CF/CF/JM
16258
4 July 2017

**RESPONSE TO SUBMISSIONS FOR SSD 5175 MOD 2
EASTERN CREEK BUSINESS HUB (LOT 2)**

PROPOSED VISUAL SCREEN
CONCEPT DESIGN

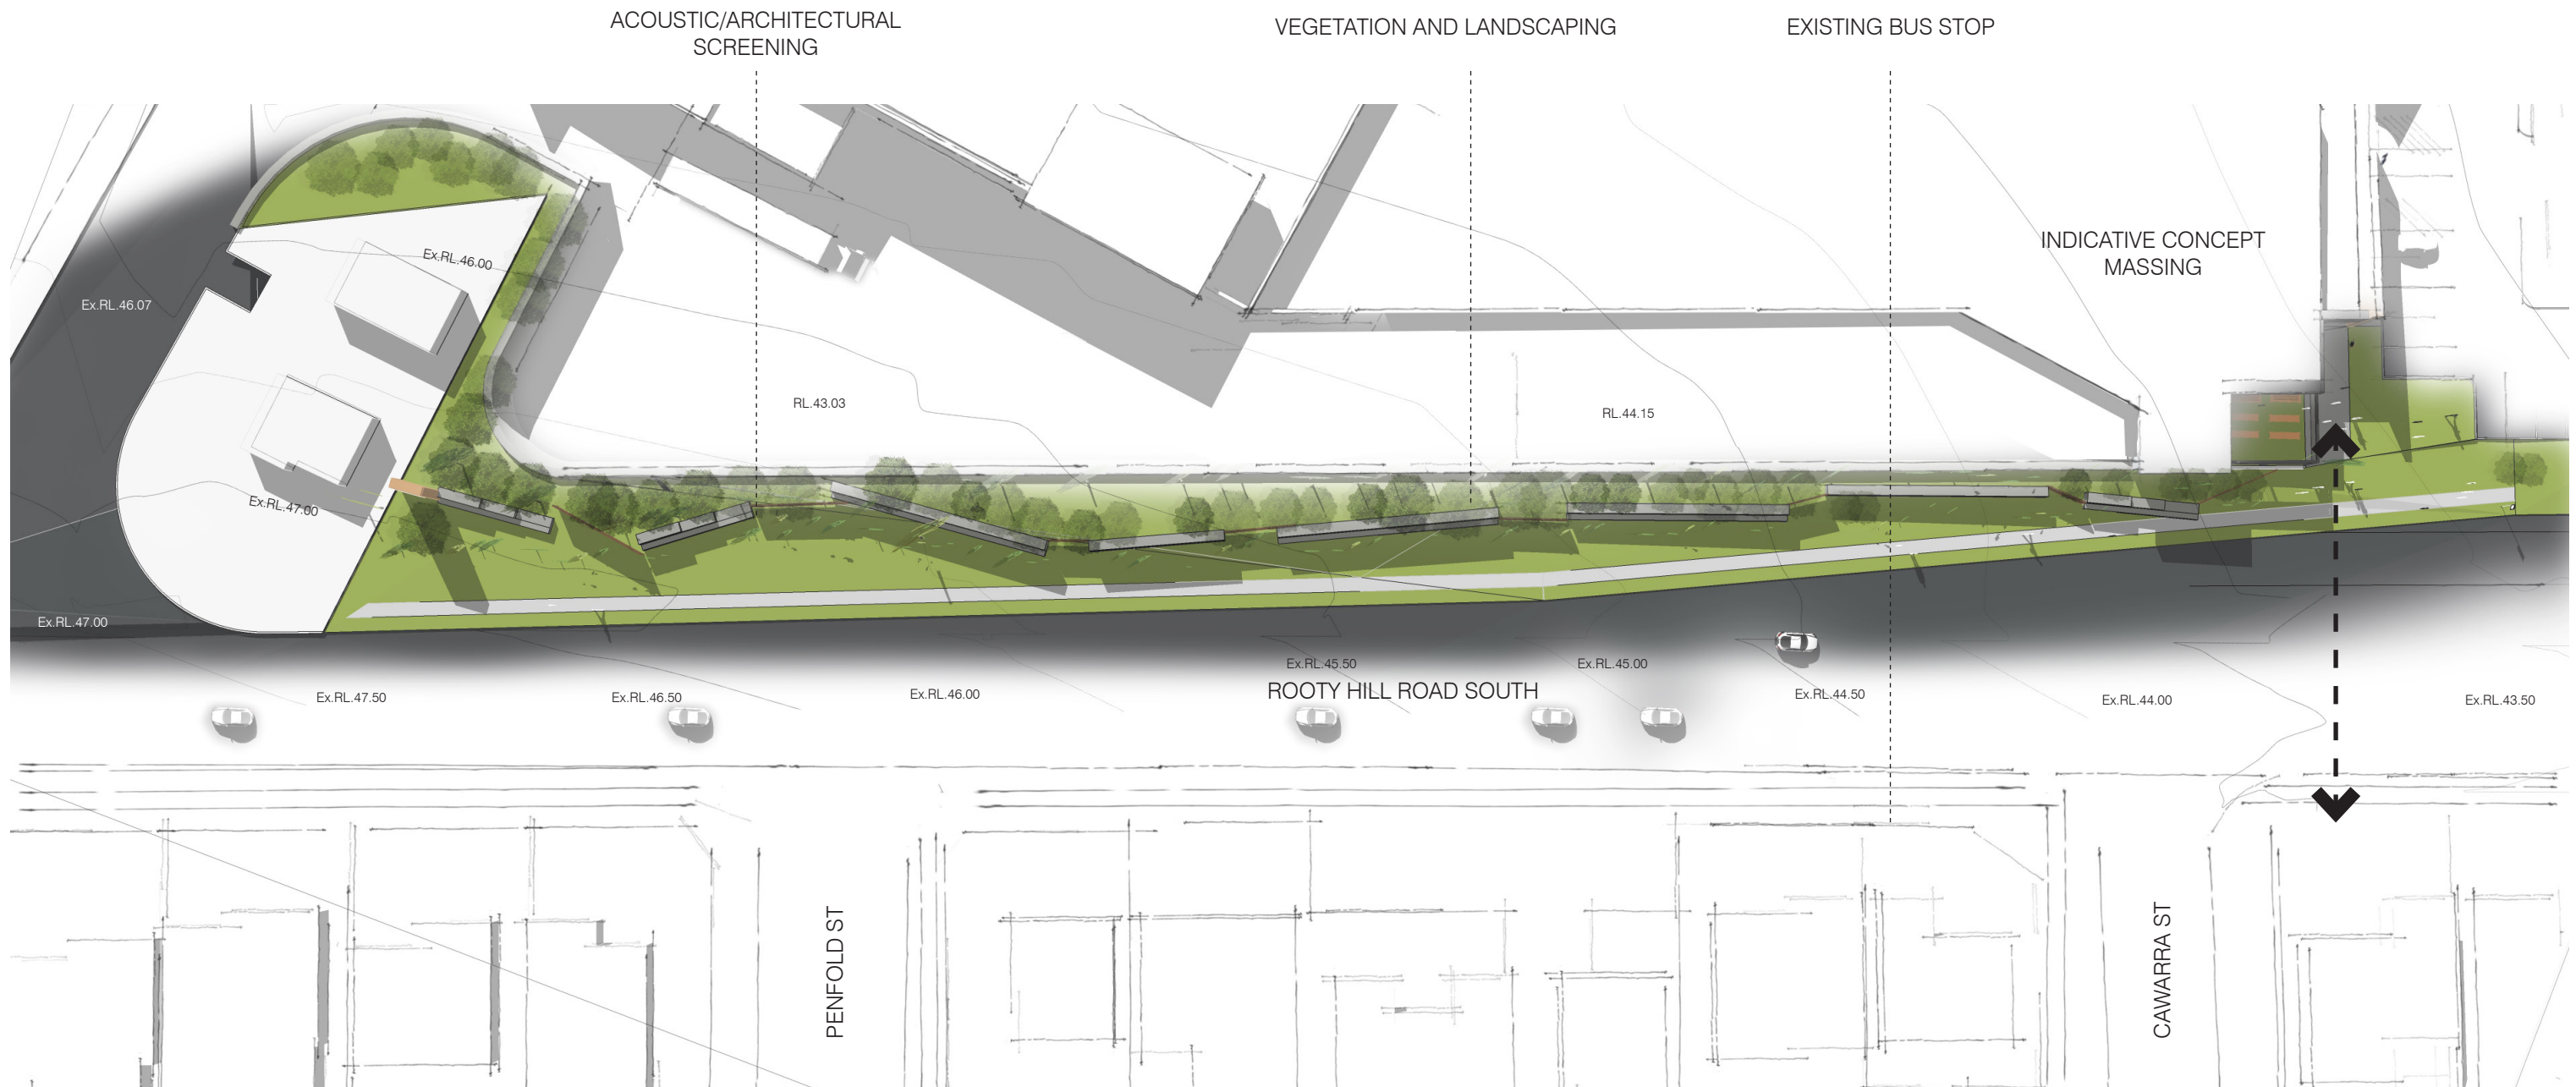
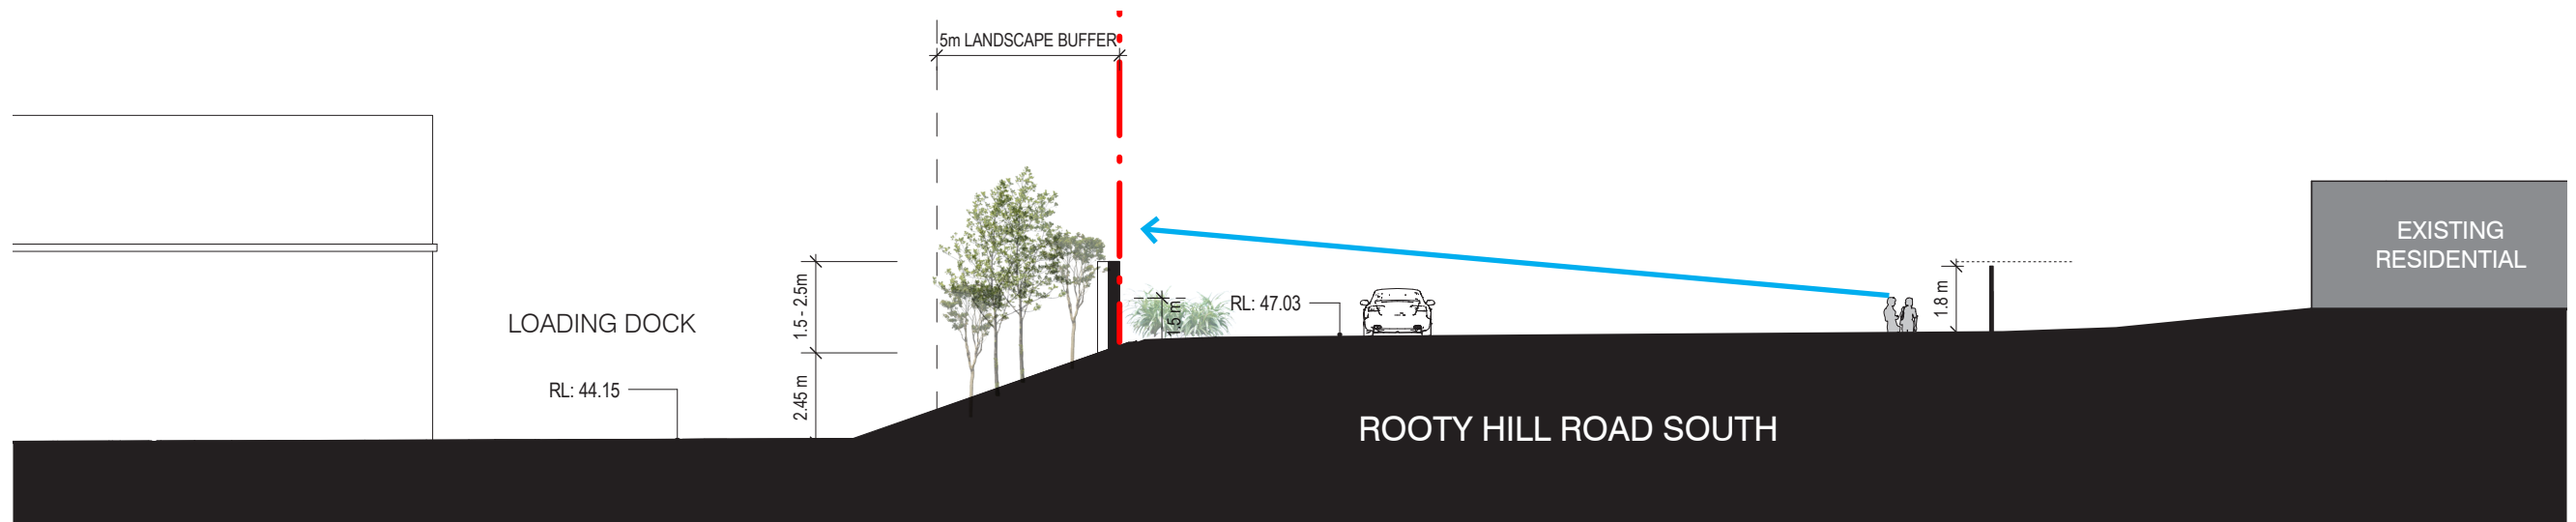
- b) Given that the majority of the building will be visible from Rooty Hill Road South, it is not appropriate for the back of the building and loading areas to address the street. The south-west corner of the building should provide an active street frontage and the design statement should be updated to include further controls about the treatment of this facade and the architectural screening provided to Rooty Hill Road South.*

At the south western corner of the site, where the level difference is less, the built form will be designed to address the Rooty Hill Road South frontage. This frontage will also be addressed through the provision of an integrated architectural screen and landscape treatment. **Figure 4** shows the indicative treatment of this frontage and further details are included within the accompanying i2c design package (**Attachment C**).

The attached design package shows the indicative treatment along the Rooty Hill Road South frontage. As shown in **Figure 4** above, and detailed within the i2c design package, the south western corner of the site will be activated by a community garden and active uses (such as cafes). The loading dock activities will occur toward the northern end of the site where the level change is greatest, thereby providing the highest level of natural screening. An integrated architectural screen and landscape treatment along this frontage will provide visually aesthetic views from adjacent properties.

SECTIONS
CONCEPT DESIGN

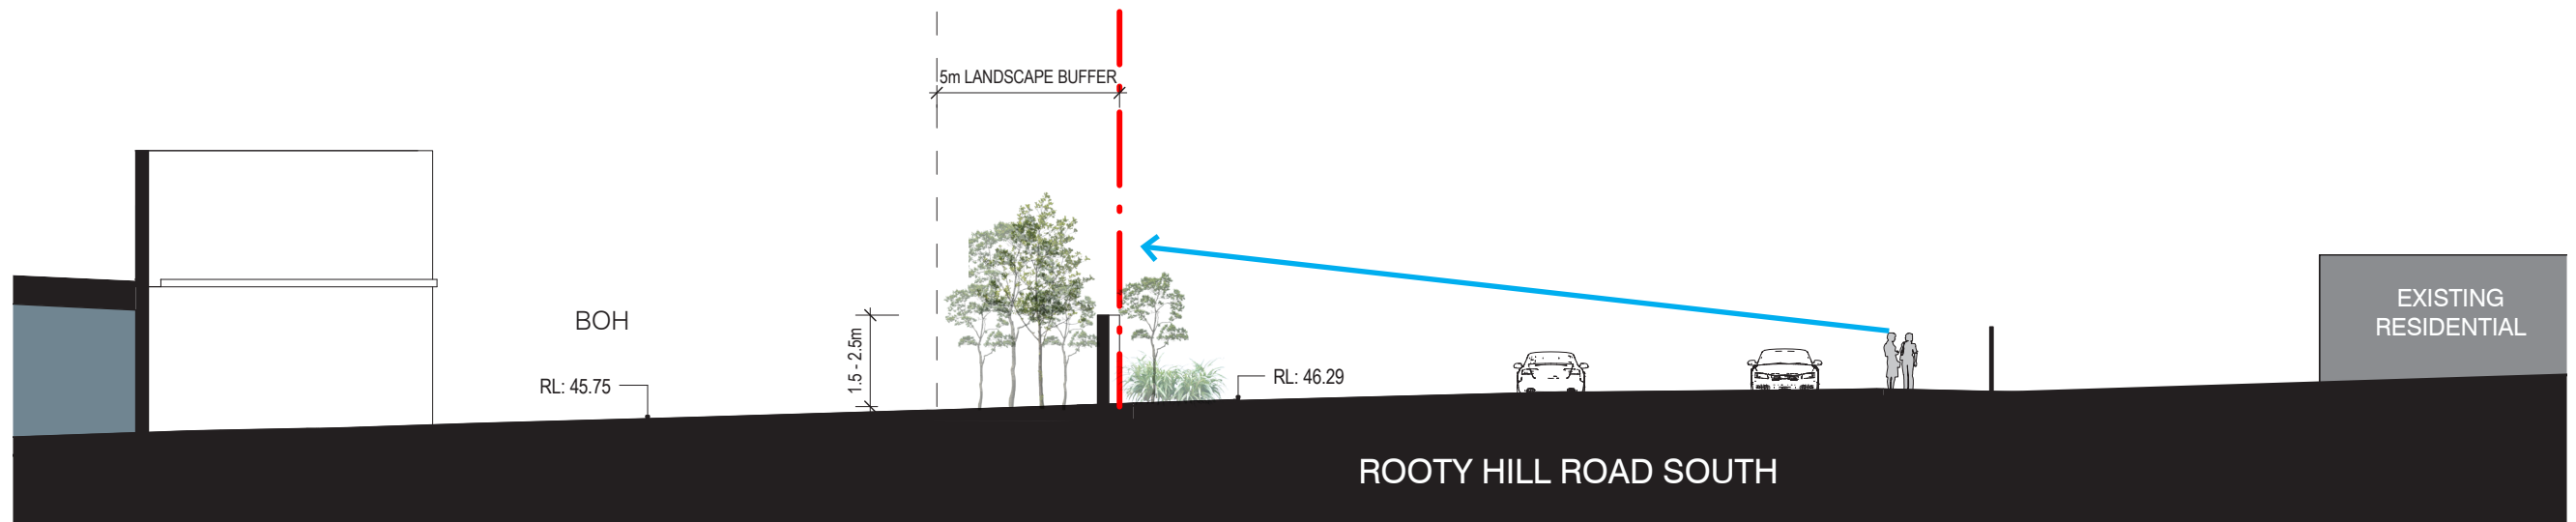
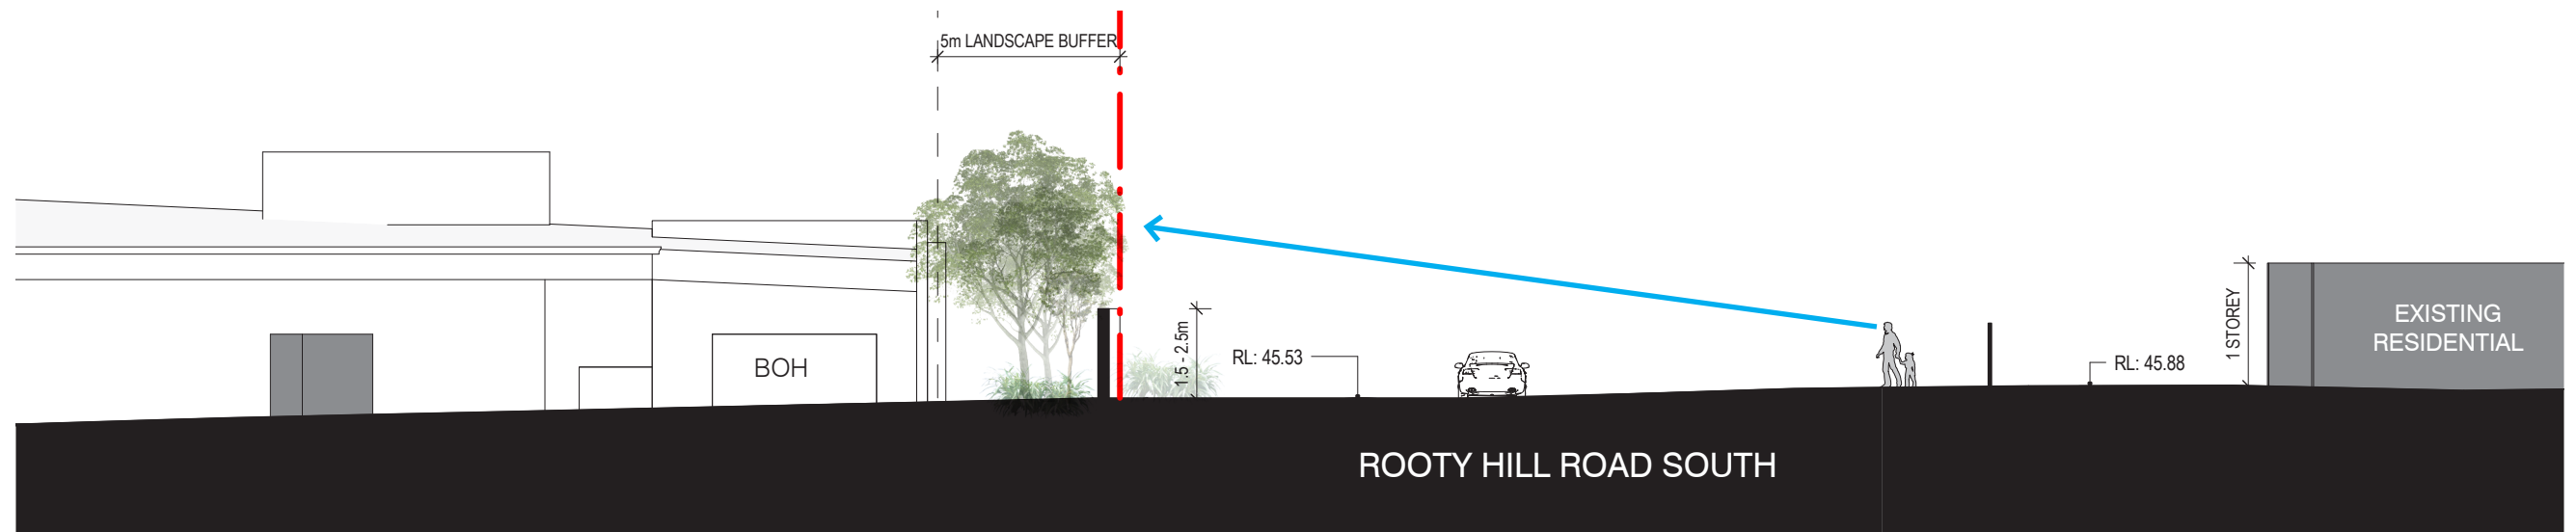
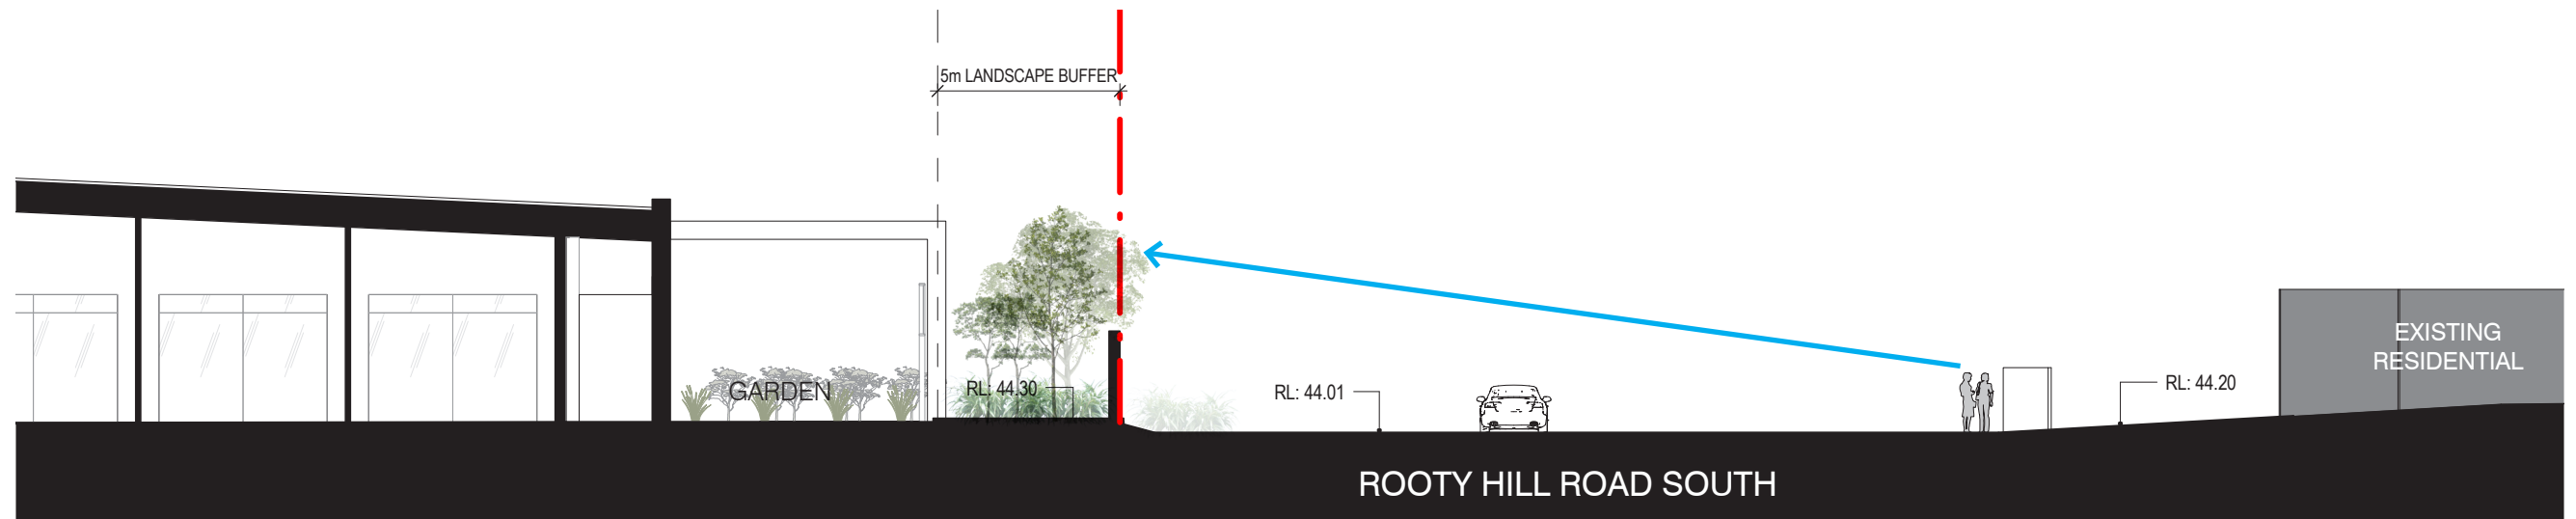
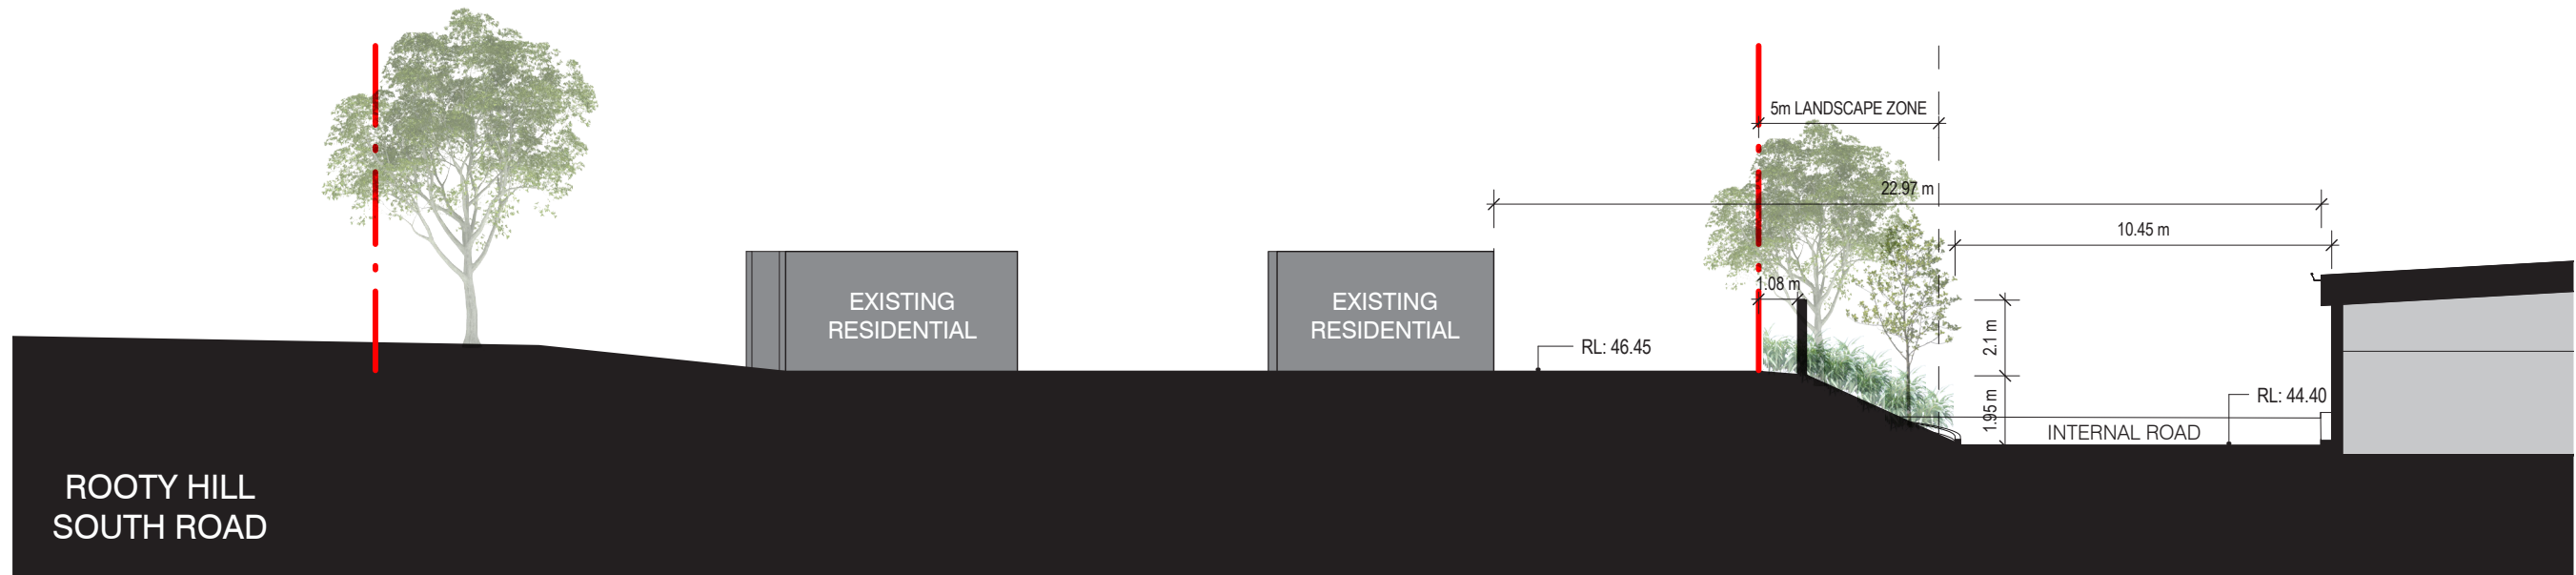
- *We disagree that the visual impact of the loading dock will be minimal. Figure 4 on page 7 of JBA's section 96(2) report indicates that the level change between Rooty Hill Road South and the loading dock will be less than 2 m. At the south-west corner of the building the level change is less than 1 m. Therefore the 'back' of the building (i.e. roller doors, waste storage area, trucks, etc.) and loading dock activities will be highly visible from Rooty Hill Road South.*

The loading dock will be located at the north western corner of the site where the level difference is greatest to the adjacent land. As demonstrated by the section plans contained within the i2c design package (**Attachment C**), the level difference at the loading dock is up to 2.05m.
